Statement of Response to An Bord Pleanála Pre-Application Consultation Opinion

Proposed Strategic Housing Development
Clongriffin SHD 2
Lands at Clongriffin, Dublin 13

Gerard Gannon Properties

| revisions  | date info       |
|--|-----------------|
| <b>Clongriffin Construction Phasing Plan</b>         |                 |

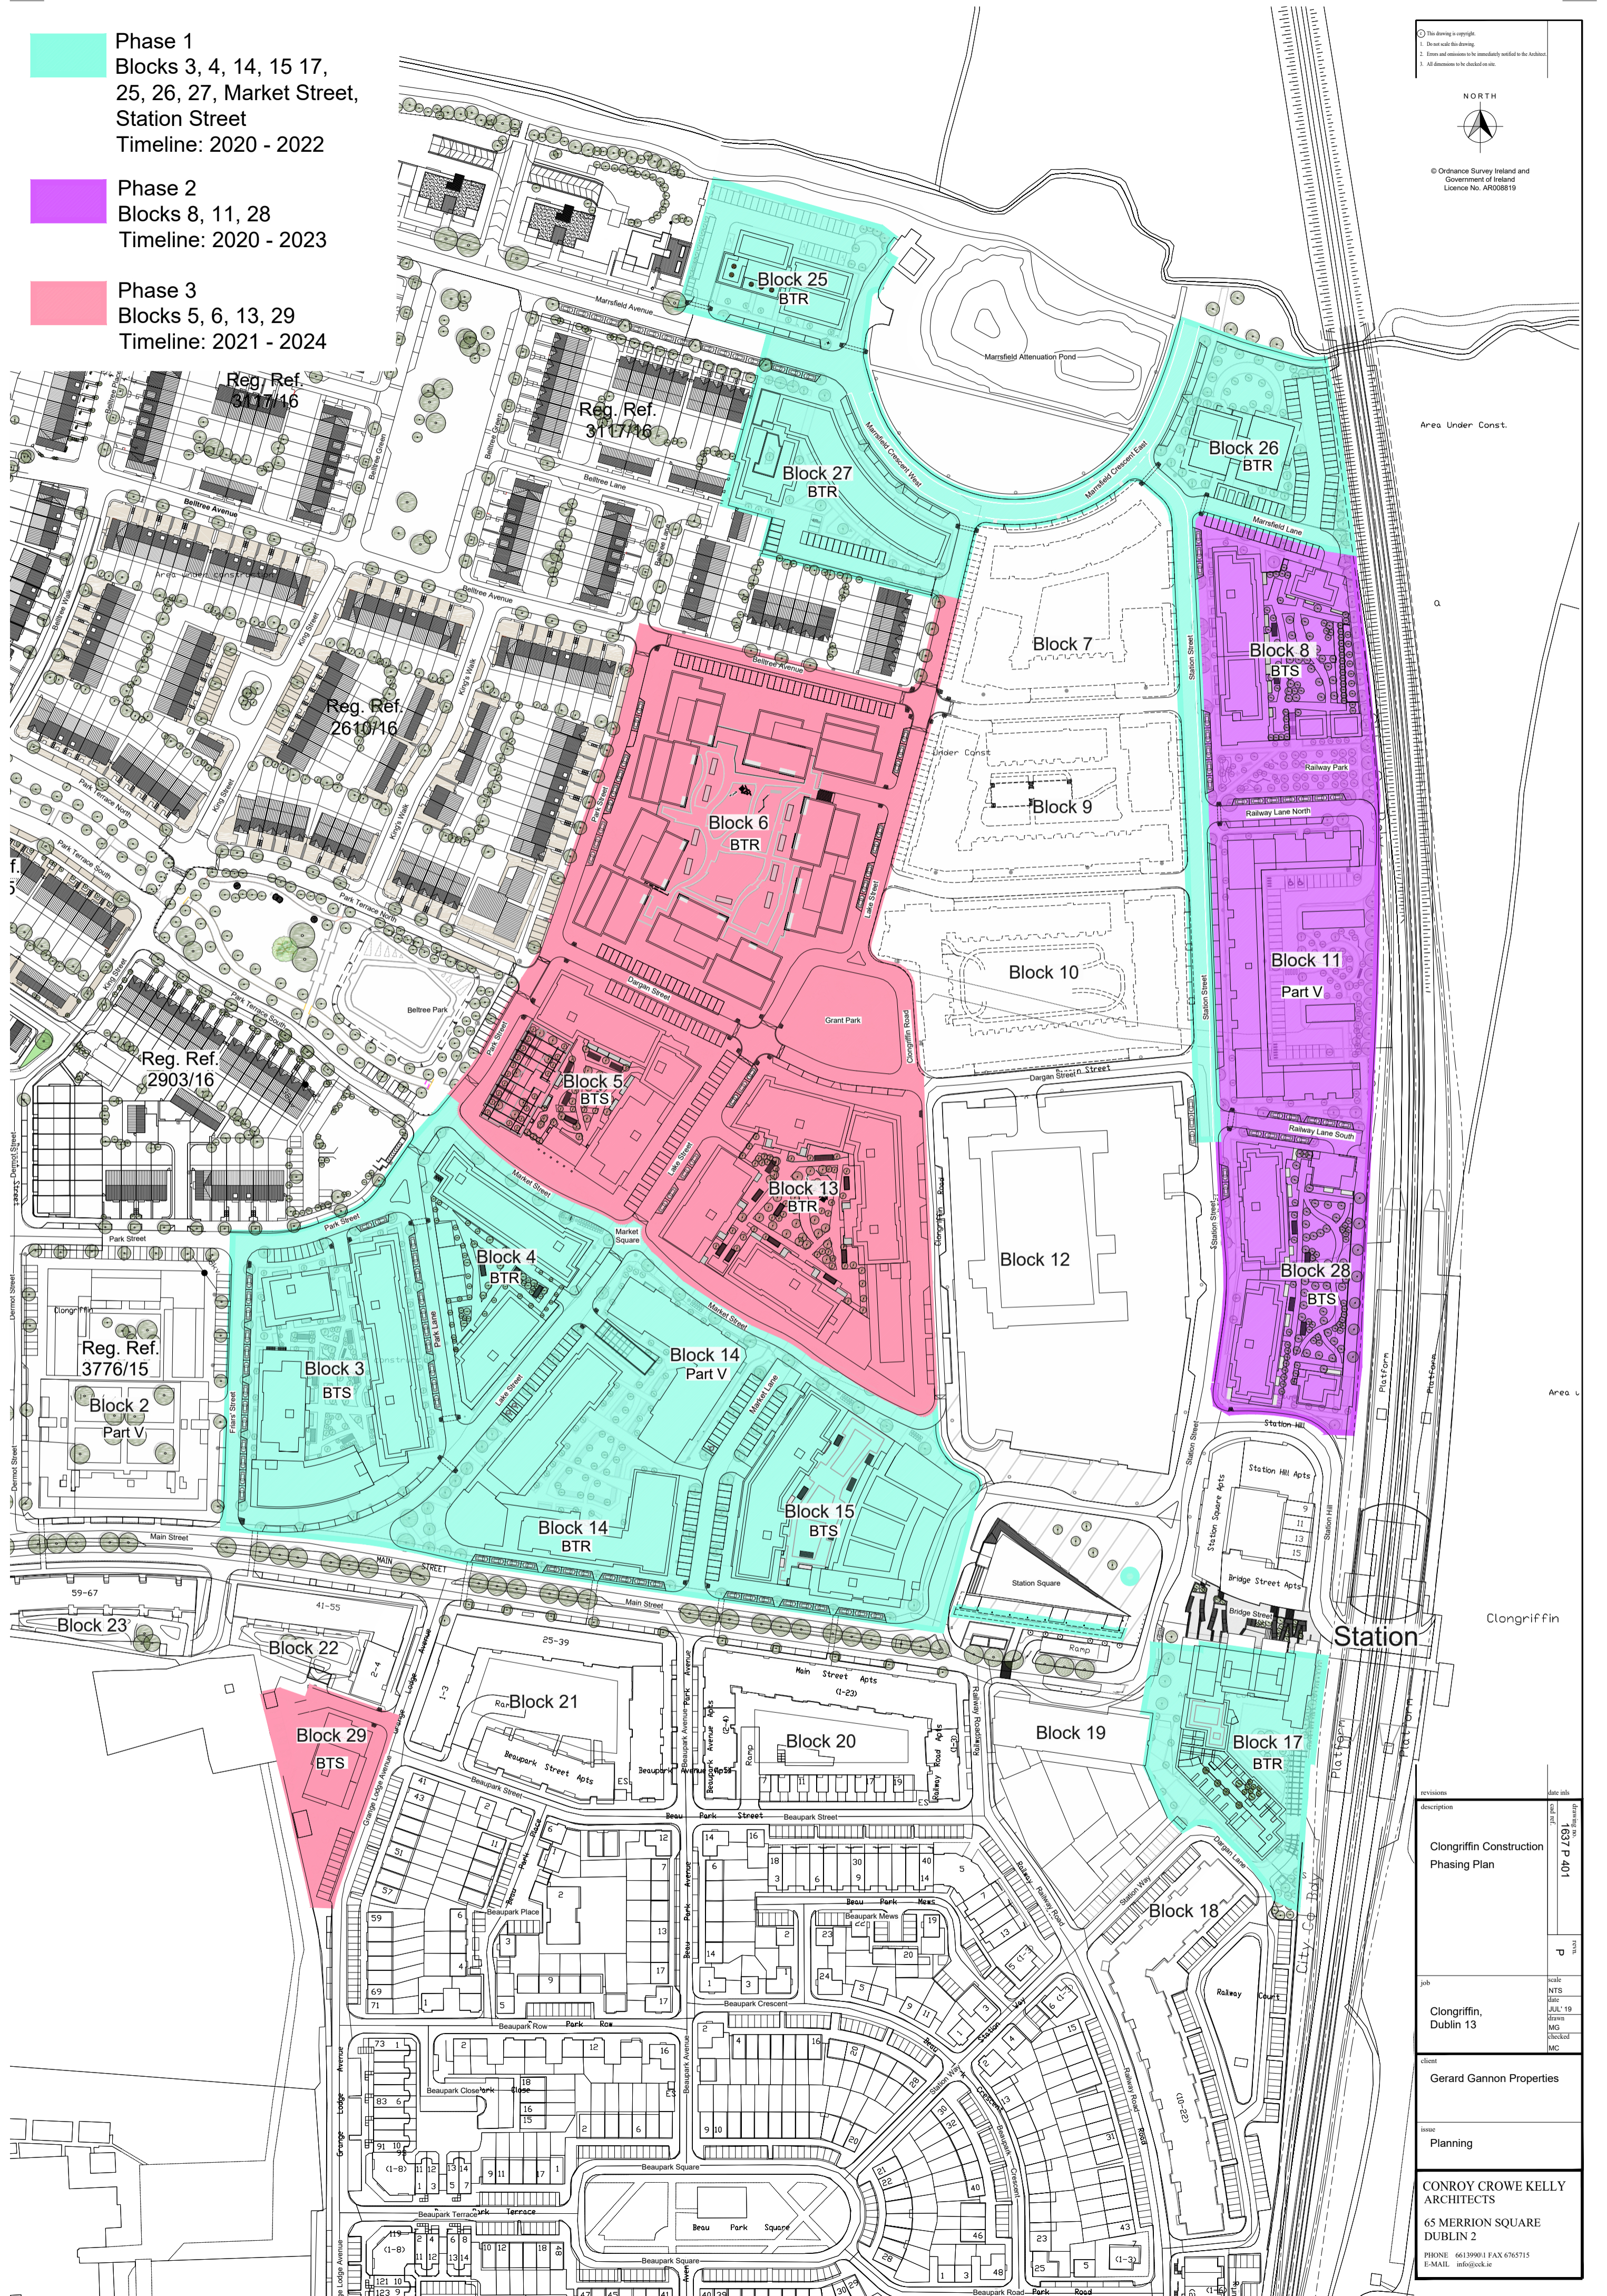
A phasing plan which includes the delivery of the town centre and in particular the Blocks in the vicinity of Main Street in an early phase of the proposed development.

A Construction Phasing Plan has now been prepared for the development. This Plan has been prepared by CCK Architects in conjunction with the applicant and is submitted as part of the planning application. This drawing can be located within the architectural drawings and documentation pack. This drawing provides information as to the proposed indicative phasing of the development and has had regard to the request of the Planning Authority to complete Main Street and the associated blocks as part of an early phase of the proposed development. It is therefore proposed to phase the development as follows:

- Phase 1 - Construction of Blocks 3, 4, 14, 15, 17, 25, 26 & 27 along with Market Street, the completion of Station Street and the completion of Marrsfield Crescent;
- Phase 2 - Construction of Blocks 8, 11 and 28; and,
- Phase 3 - Construction of Blocks 5, 6, 13 and 29.

With regards to the SHD 2 proposal, Blocks 4 and 14 form part of the first phase of development, whilst Block 5 will be constructed in the third phase. For further information in this regard, please refer to CCK Architects Drawing No. 1637 P 401 titled Clongriffin Construction Phasing Plan.

description
Clongriffin SHD 2
Taking in Charge Plan

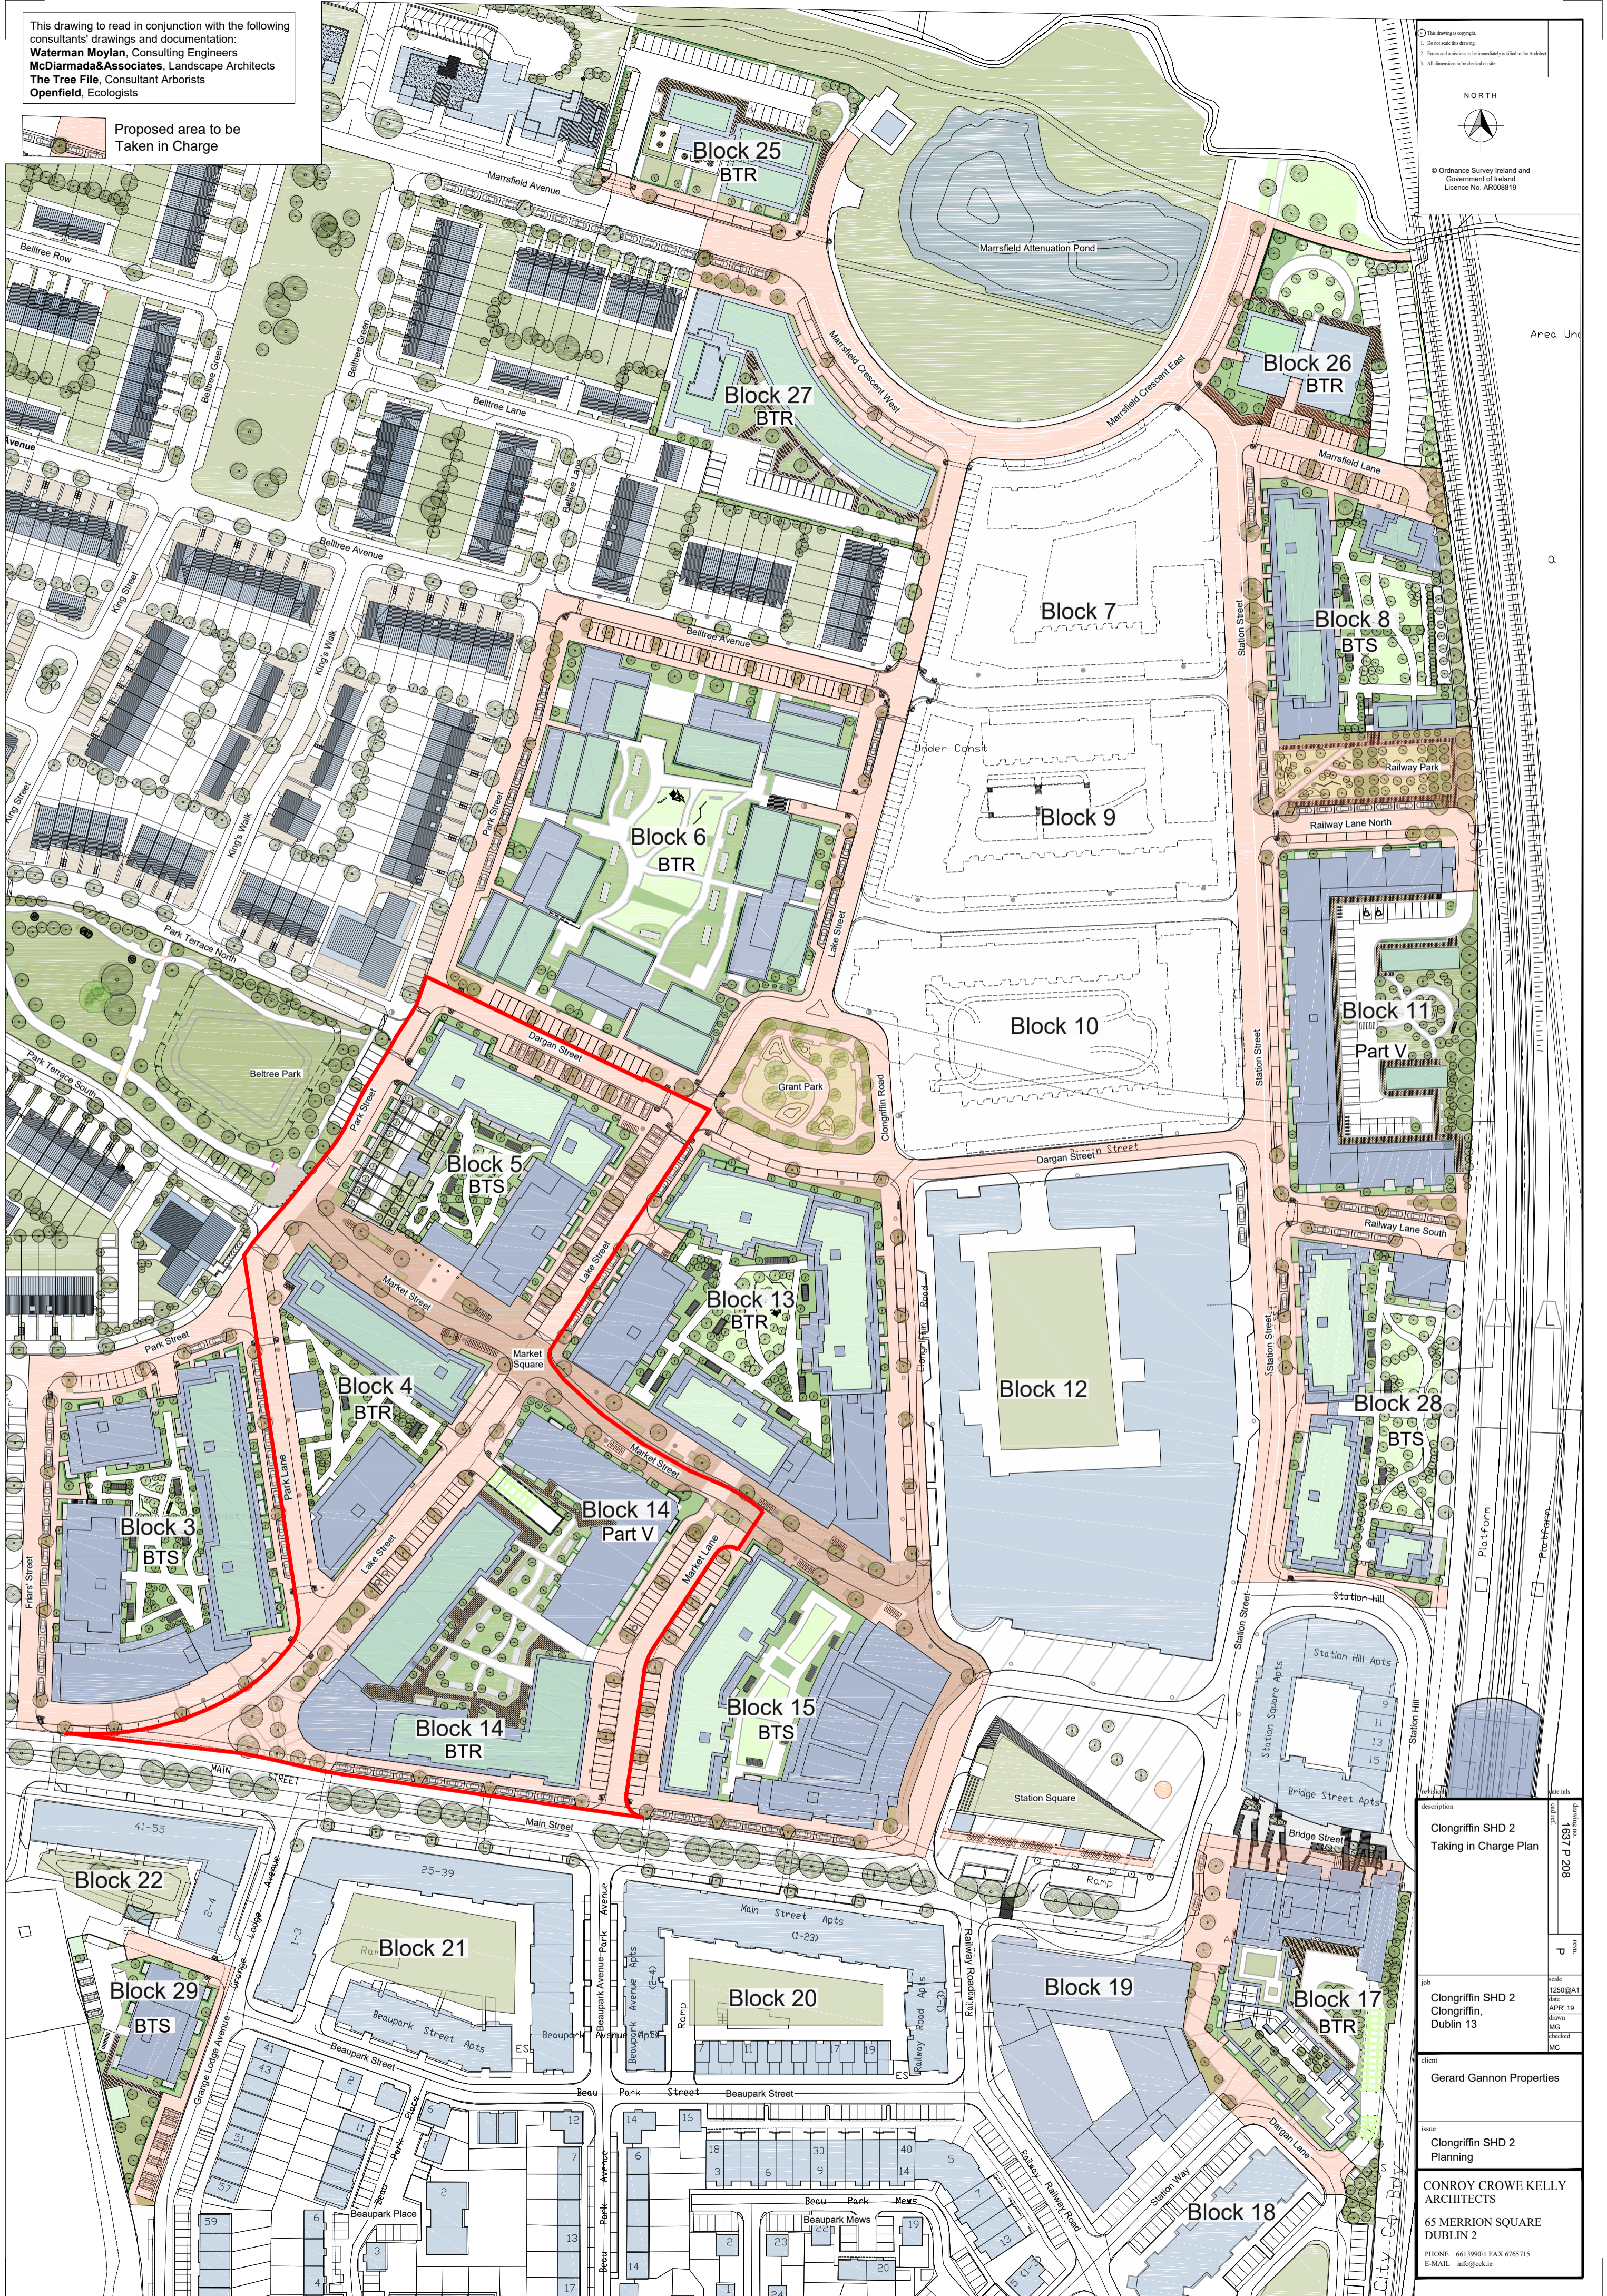
A site layout that details any areas to be taken in charge by the local authority.

Downey Planning can confirm that the road/street network and associated infrastructure is proposed to be Taken in Charge by Dublin City Council as set out and indicated on the enclosed Clongriffin SHD 2 Taking in Charge Plan drawing No. 1637 P 109 prepared by CCK Architects. The internal communal open space areas are to be maintained by a private management company. Please refer to the submitted Taking in Charge Plan enclosed with the application for further details. This drawing can be located within the architectural drawings and documentation pack.
